From: Jonathan Best <Jonathan.Best@arun.gov.uk>
Sent: 25 June 2026 11:05
To: Planning.Responses <Planning.Responses@arun.gov.uk>
Cc: Simon Davis <Simon.Davis@arun.gov.uk>
Subject: P/30/26/OUT + P/31/26/OUT updated ecology comments

Land North of Summer Lane Pagham.

I have reviewed the updated information for ecology and Biodiversity Net Gain.

Pagham Phase 4b (120 Units) - Post Development Habitats

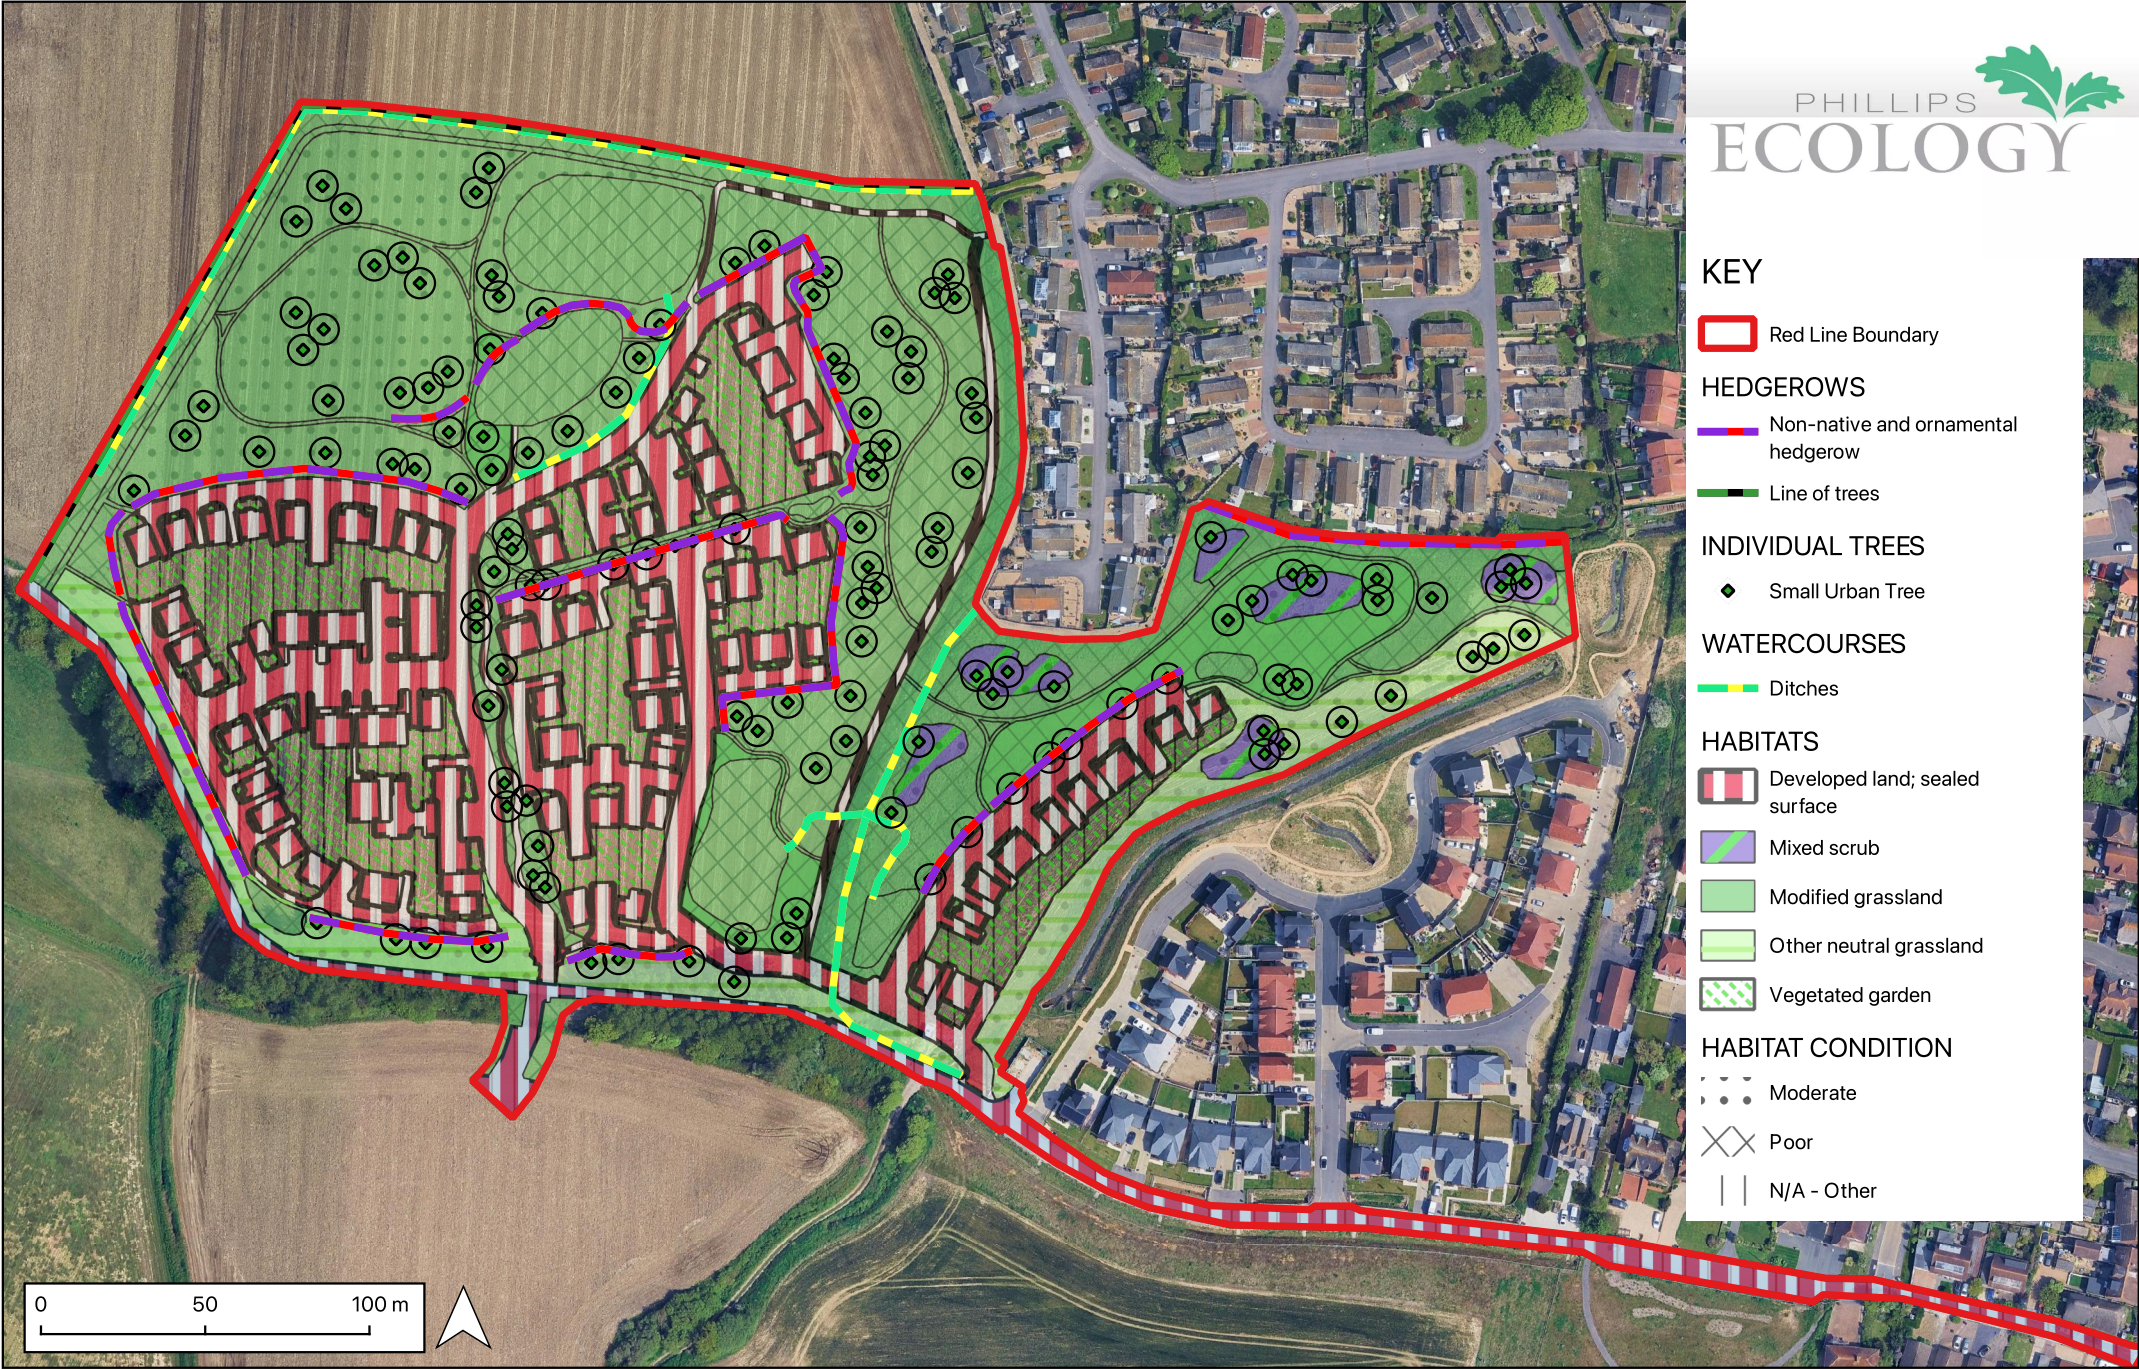
A post development habitat plan has been provided. This is acceptable.

There are still errors in the statutory metric.

There are errors contained within the BNG metric relating to the pre and post areas as they do not match. For on-site *area habitats*, the total area of lost habitat was found to be 8.01 ha, and the total area of created habitat was found to be 7.99 ha. These areas should be equal. Tab A2 habitat creation strategic significance is missing.

Also, The numbers of trees are missing.

These errors can be addressed at the reserved matters stage.
